## EL PASO COUNTY GRADING AND EROSION CONTROL PLAN CHECKLIST

SF2235

DRAWN BY MES (H) 1" = 50' SHEET 5 OF 53

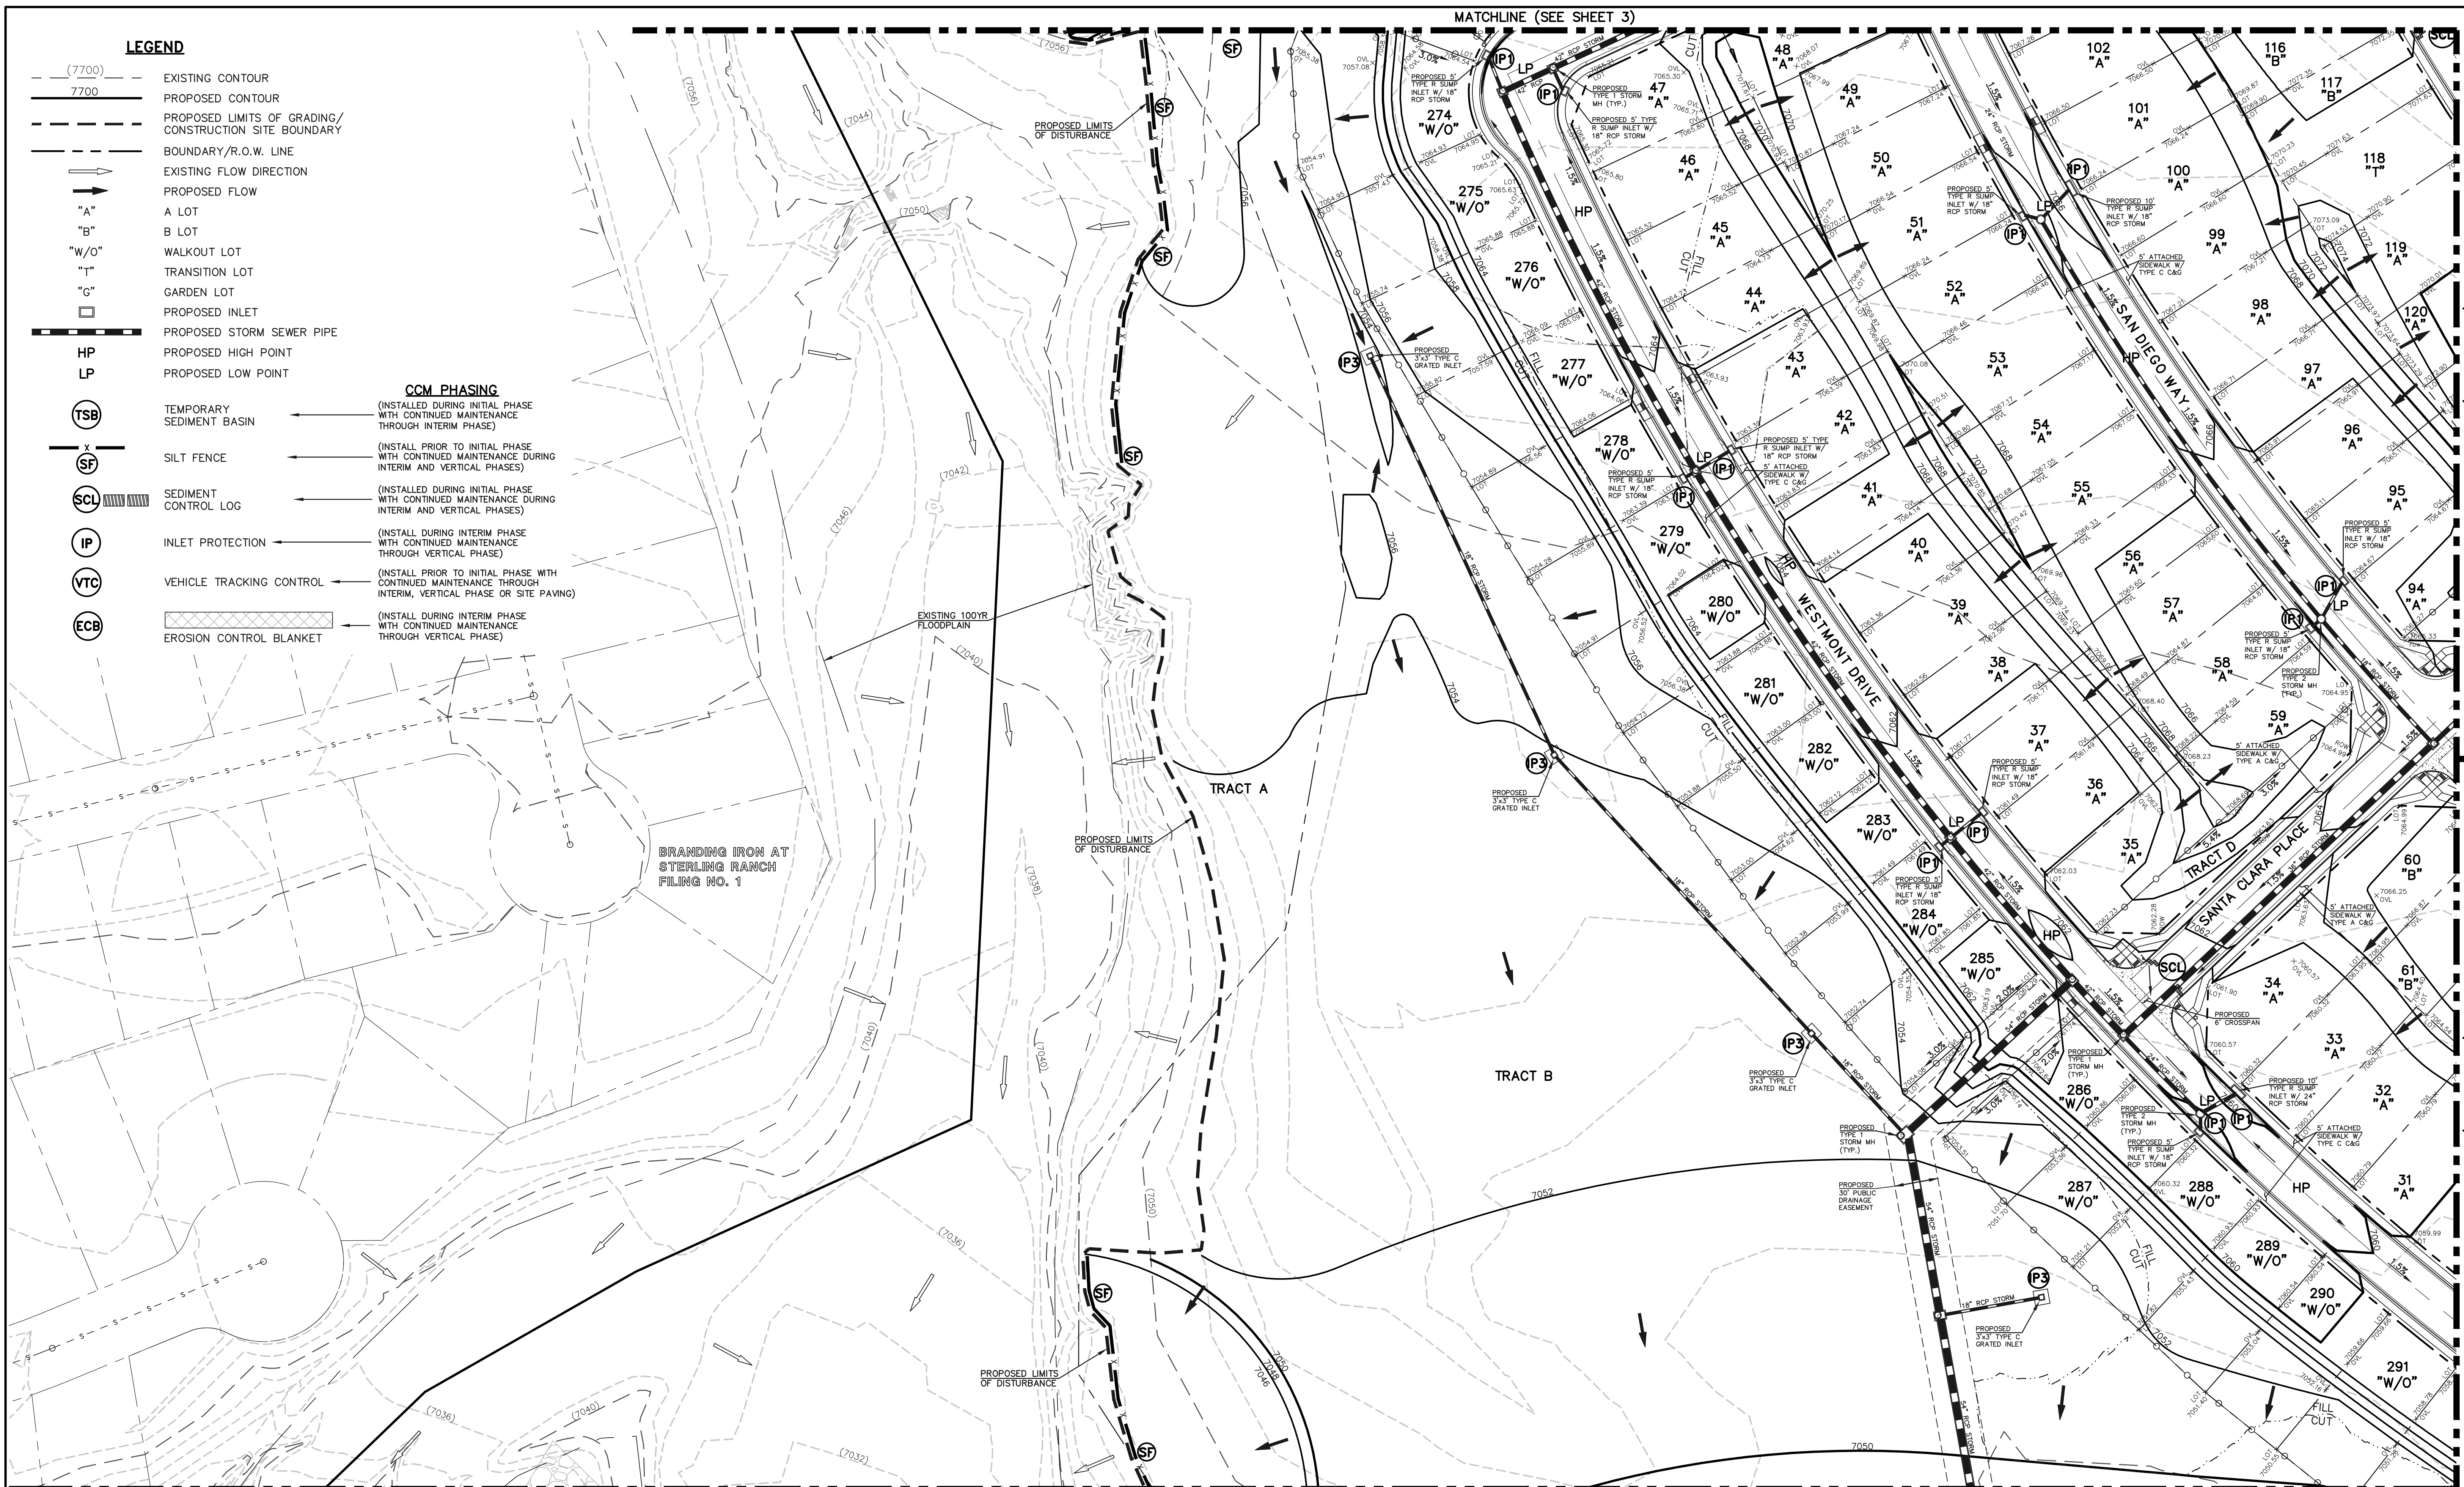
See comment on Sht 5 of CDs

DESIGNED BY	MES	SCALE	DATE	08/31/22
DRAWN BY	MES	(H) 1" = 50'	SHEET	6 OF 53
CHECKED BY	(V)	1" = N/A	JOB NO.	1183.30

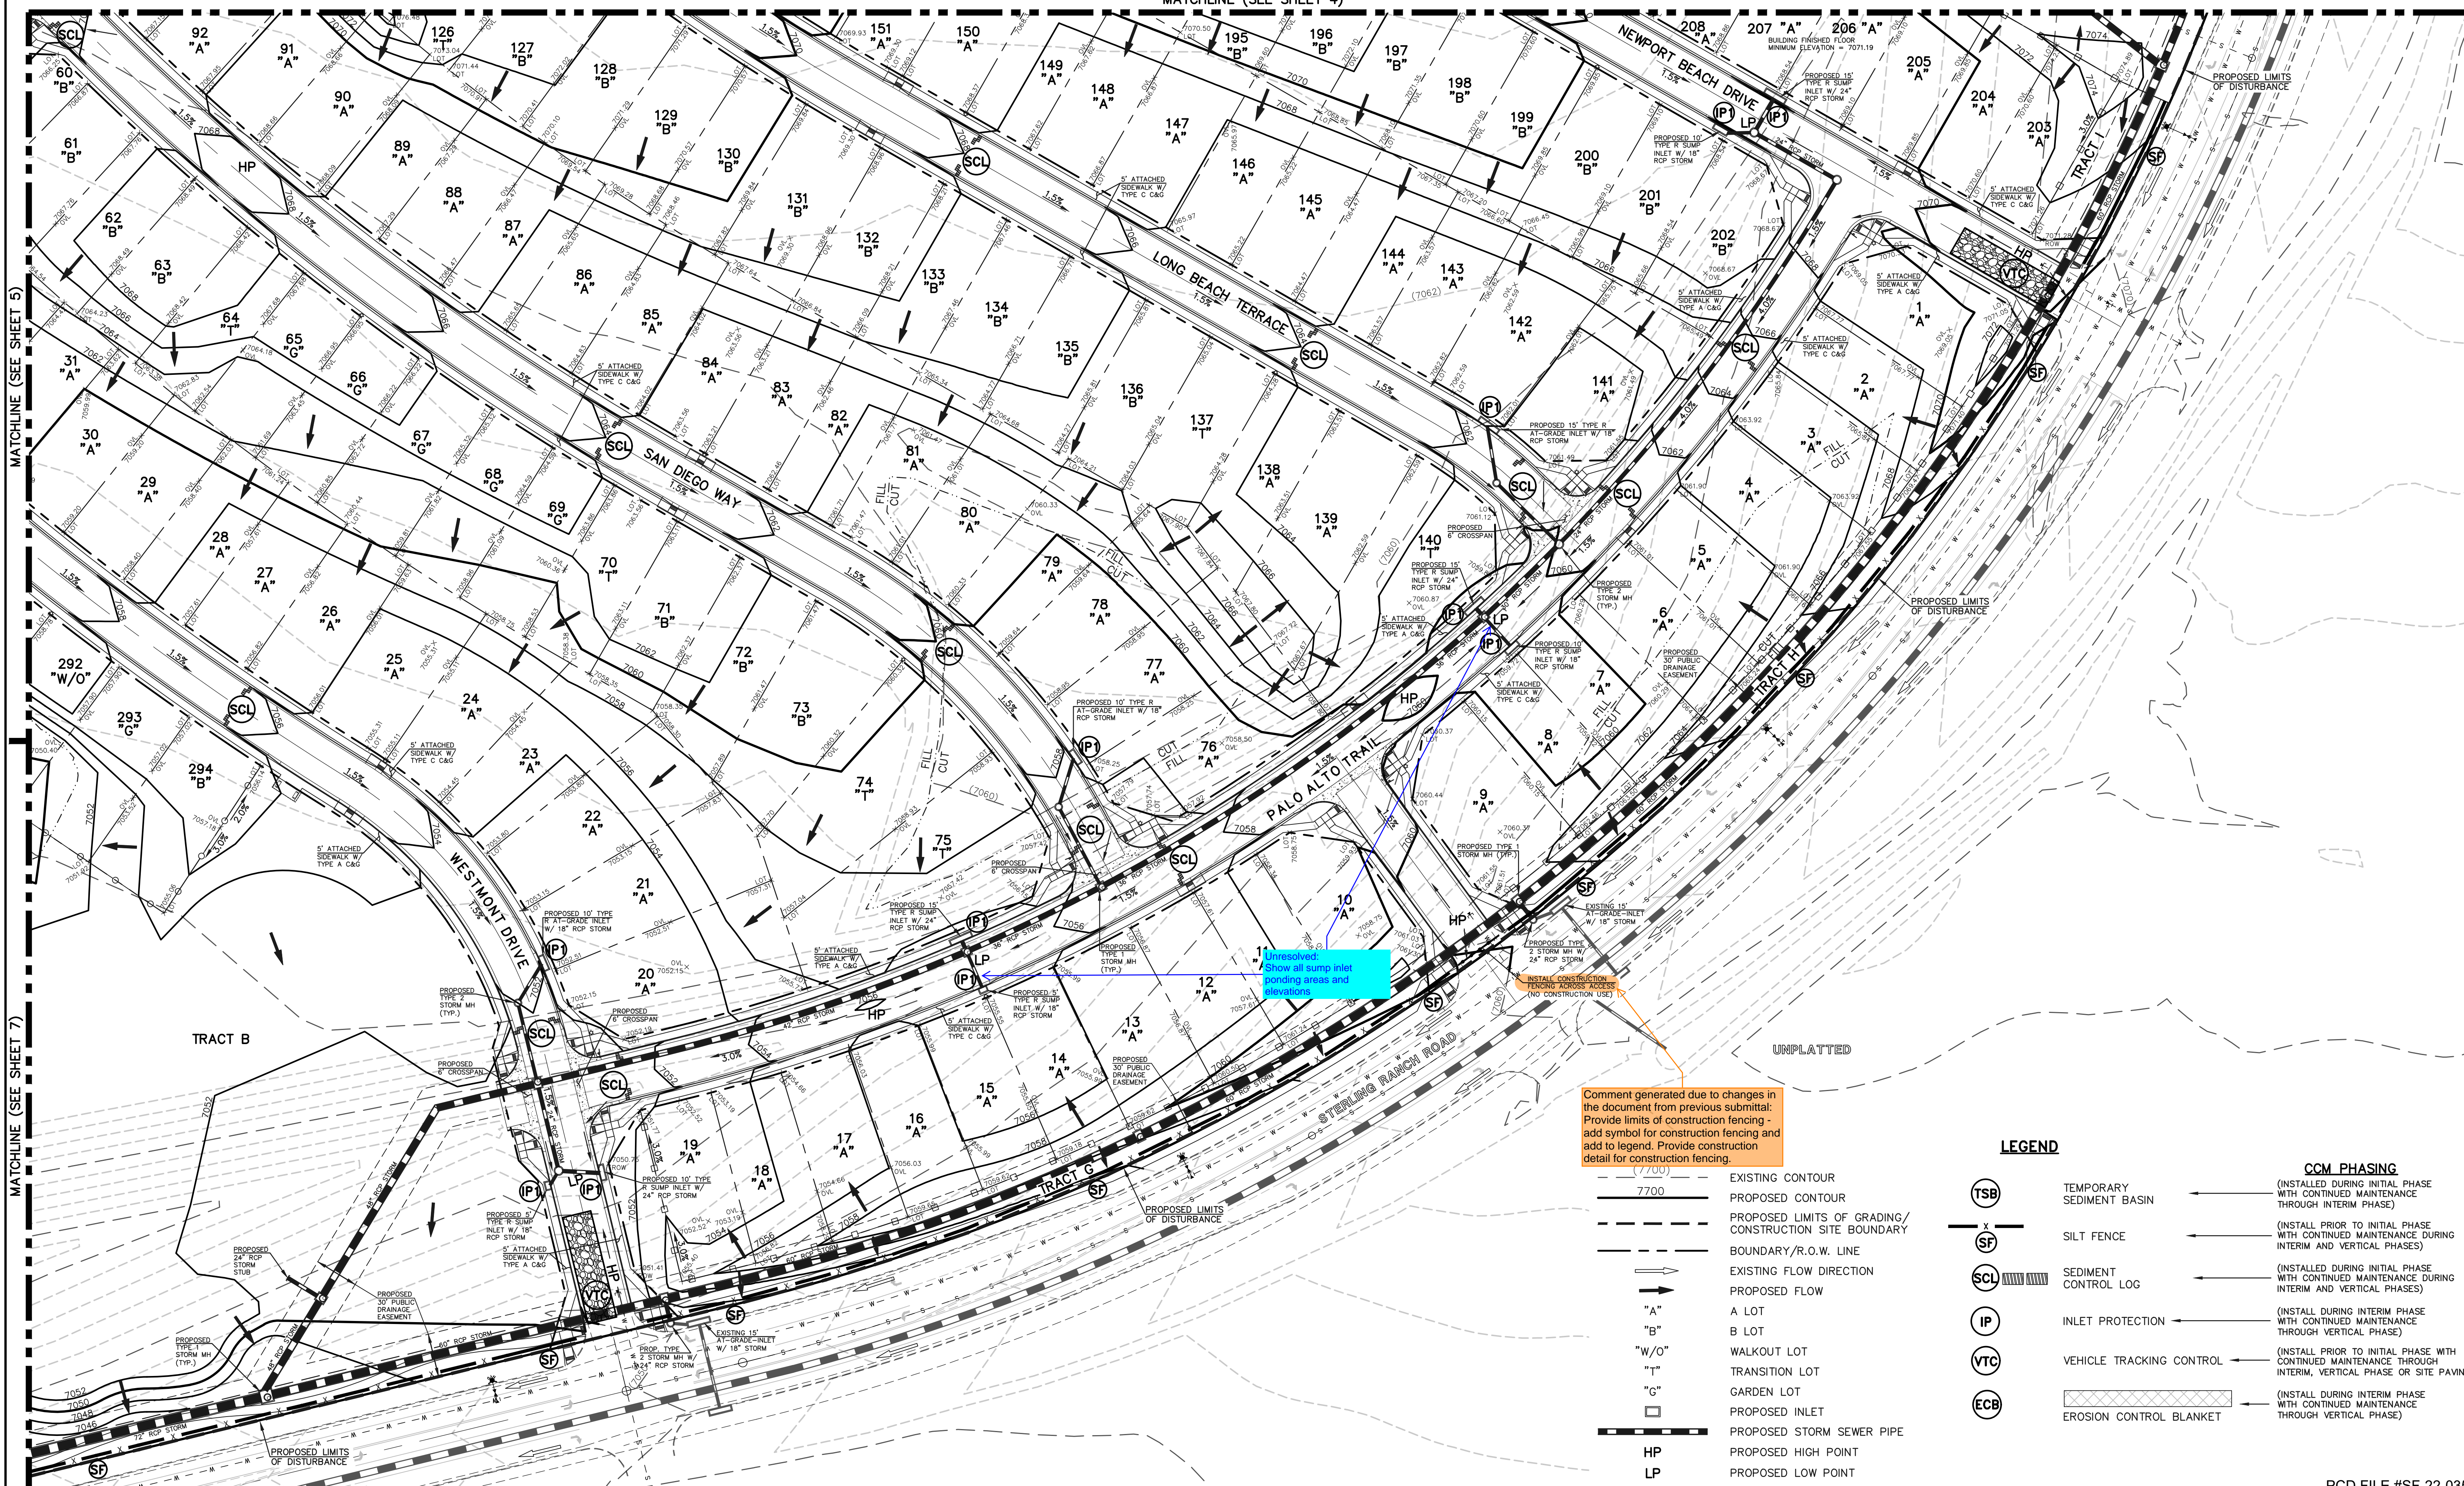
See comment on Sht 6 of CDs
